Case Officer: Emma Whitley

Recommendation: Approve

Proposal: Two-storey front and rear extensions, with new pitched roofs replacing flat roof area to side of the property. enlargement of vehicle access width in stone boundary wall. Revised scheme of 21/00869/F to change all roof coverings from plain tiles to blue slates

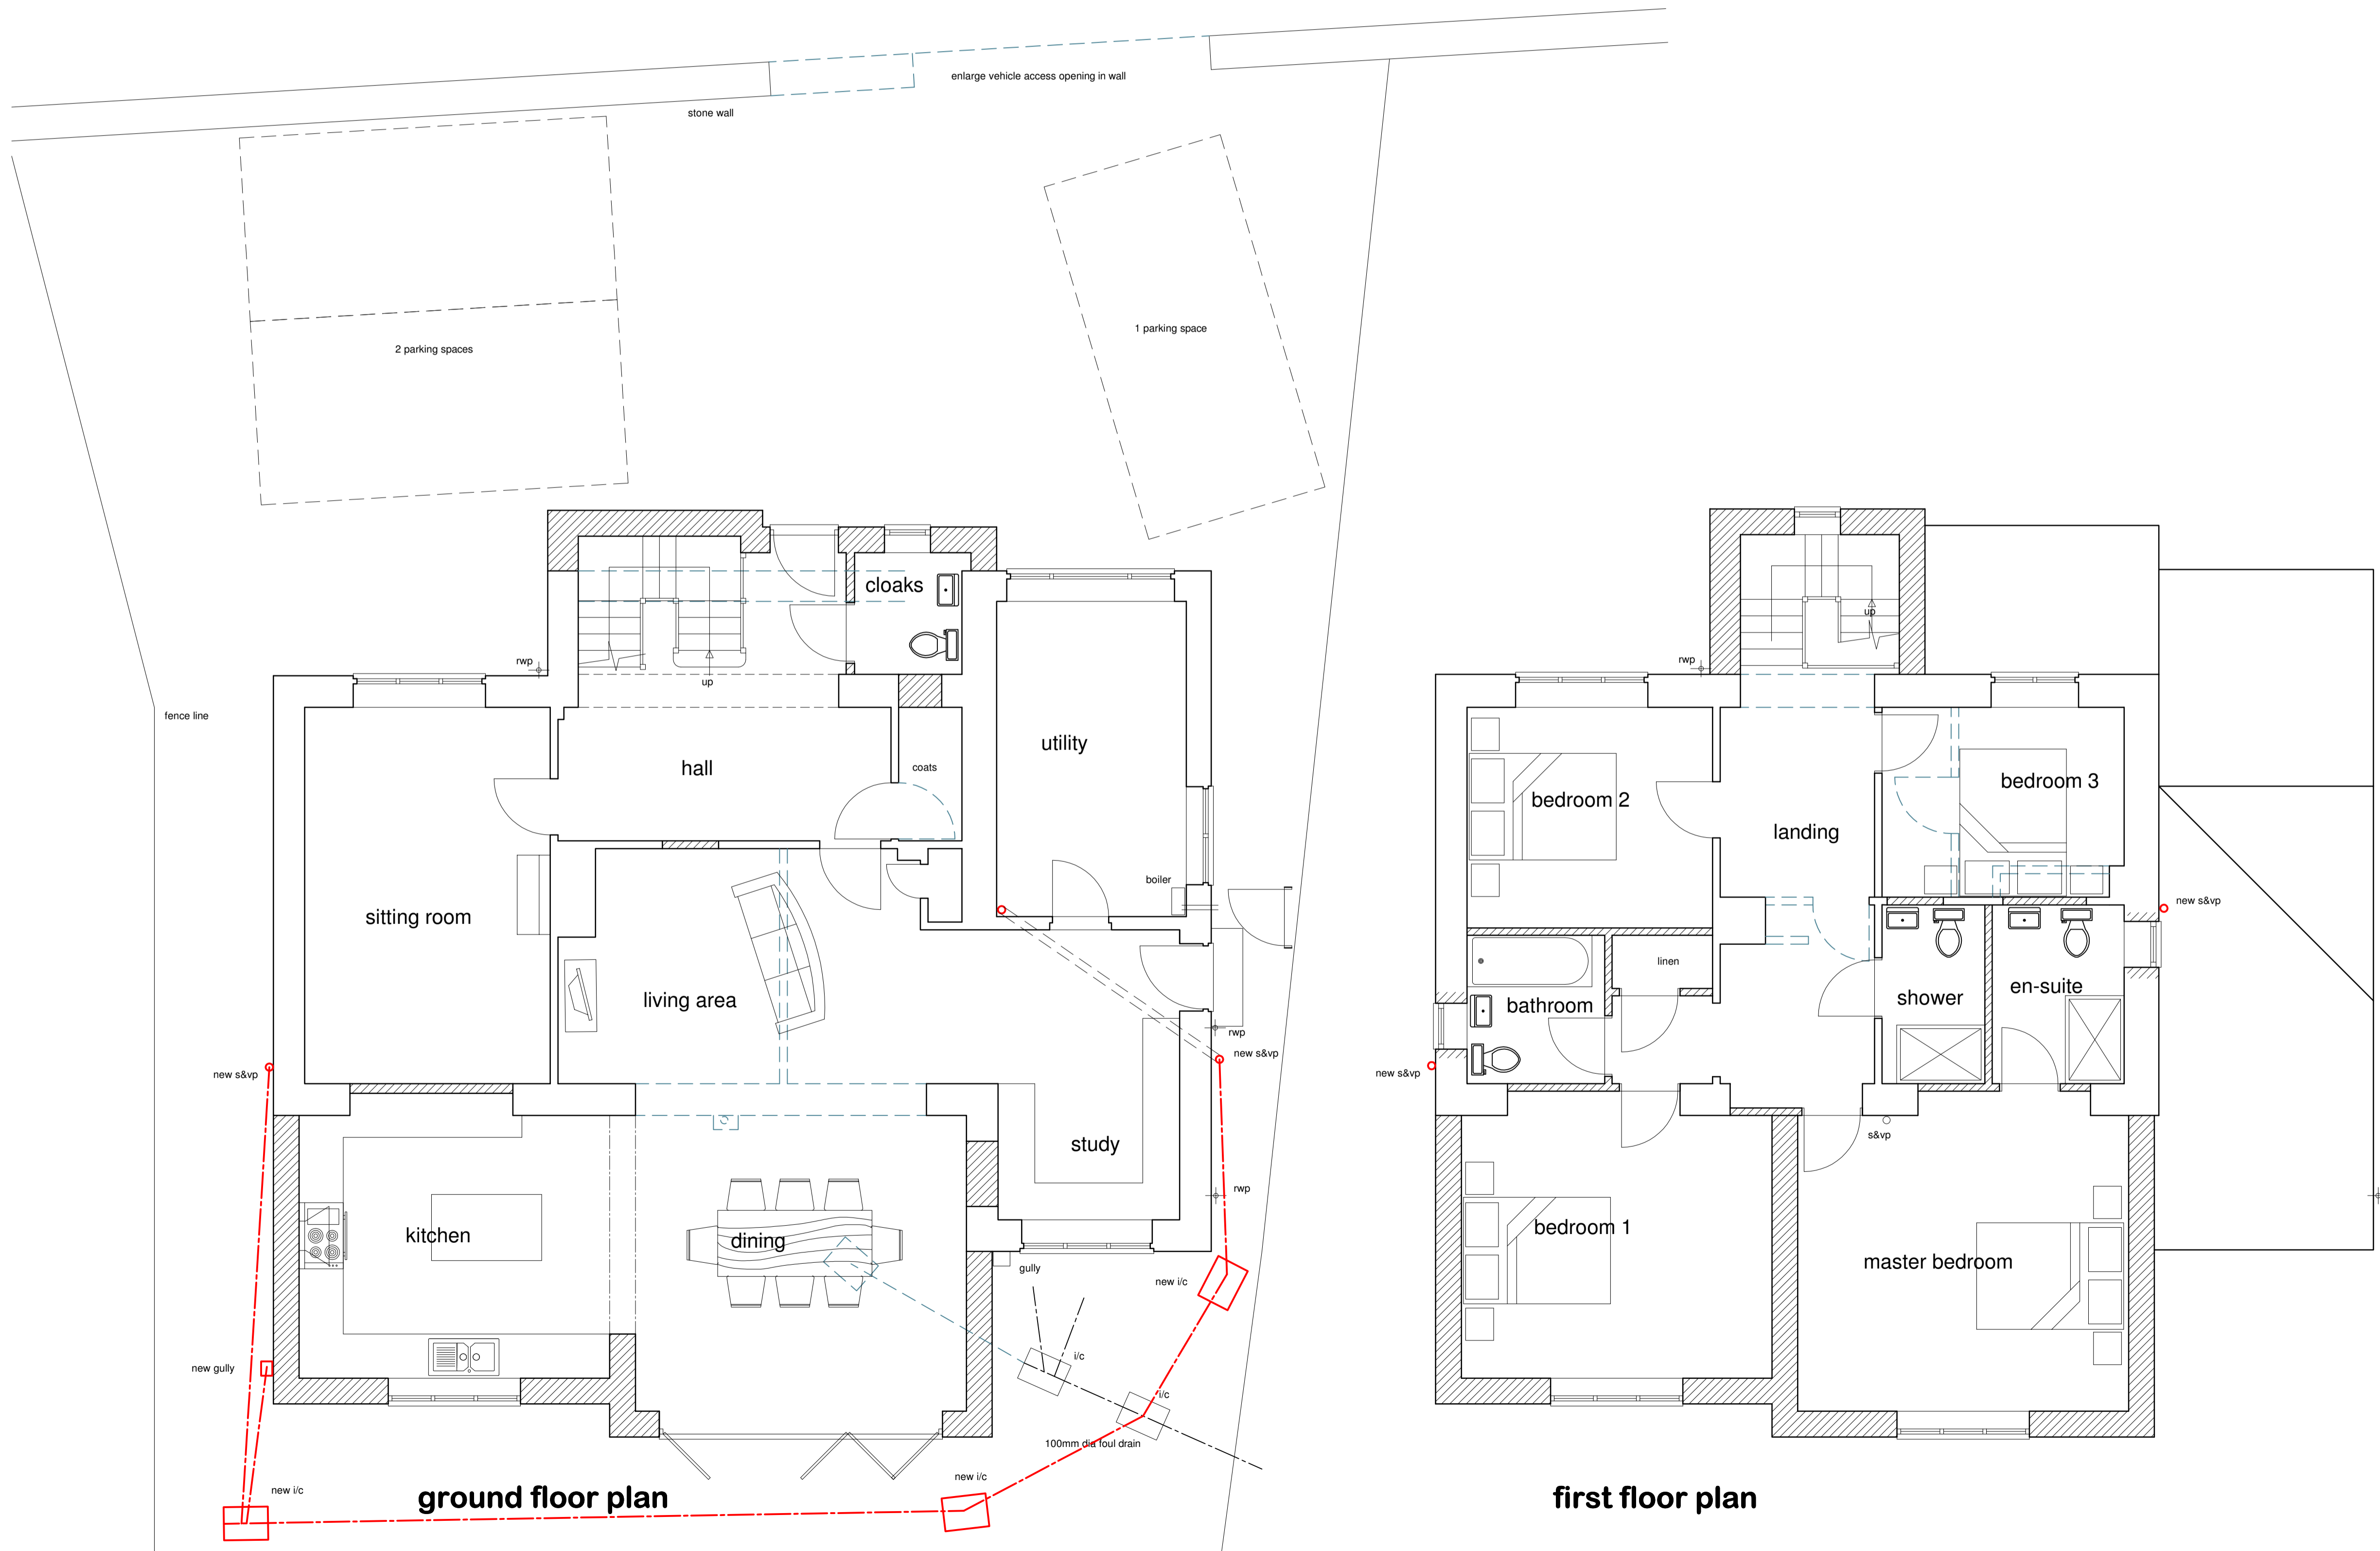
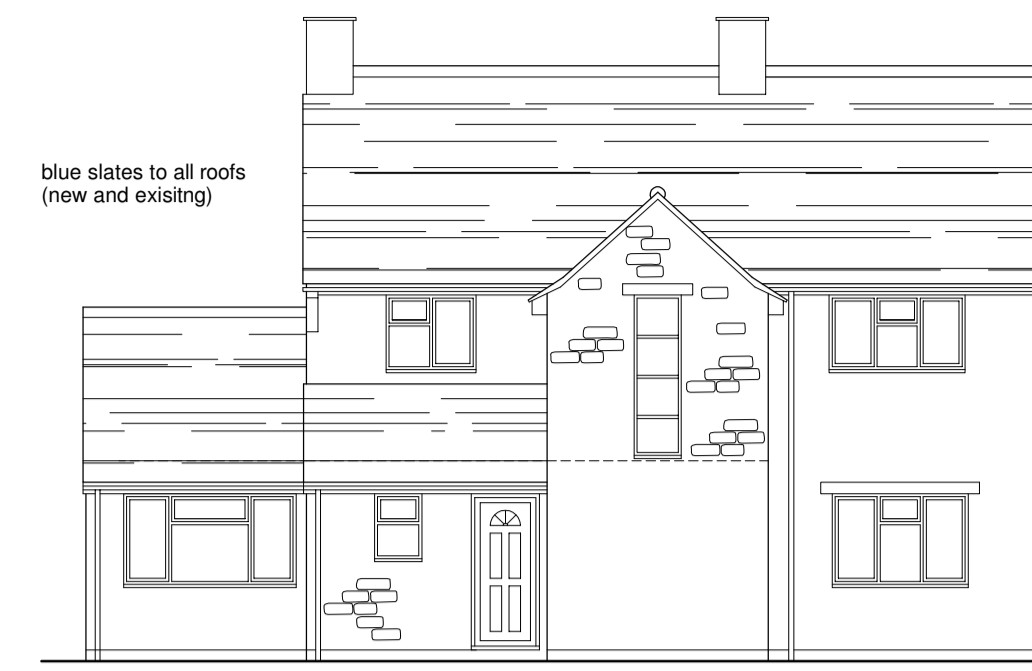
The change to roof tiles is not considered to result in any additional impact to the Bodicote Conservation Area than that previously assessed and is therefore not considered to result in demonstrable harm to the designated heritage asset.

Conclusion: the proposals, on balance, are considered not to result in demonstrable harm to the Bodicote Conservation Area and are considered acceptable in this regard. The proposed roof tiles would be added to the original dwelling as well as the approved new additions. I consider that the change would be in keeping with the character of the street scene.

The roof ridge height of the single storey side extension would measure approximately 4.3 metres and would have an eaves height of 2.3 metres, which is considered to still be of a considerable height given its single storey scale. The proposals have not been reduced compared with the plans submitted at pre-application stage, however I do not consider that this element would result in demonstrable harm with regards to the Old Thatch and are therefore not so harmful so as to warrant refusal.

The rear extensions would cause minimal impact to the amenities of the residents of the Old Thatch as it would be stepped back approximately 4 metres and would have no windows facing them. The two-storey extensions would be approximately 7 metres from the residents at Spring Cottage. However, given the relationship and orientation of the two buildings, on balance, I am satisfied that any harm would be limited and would not warrant a refusal.
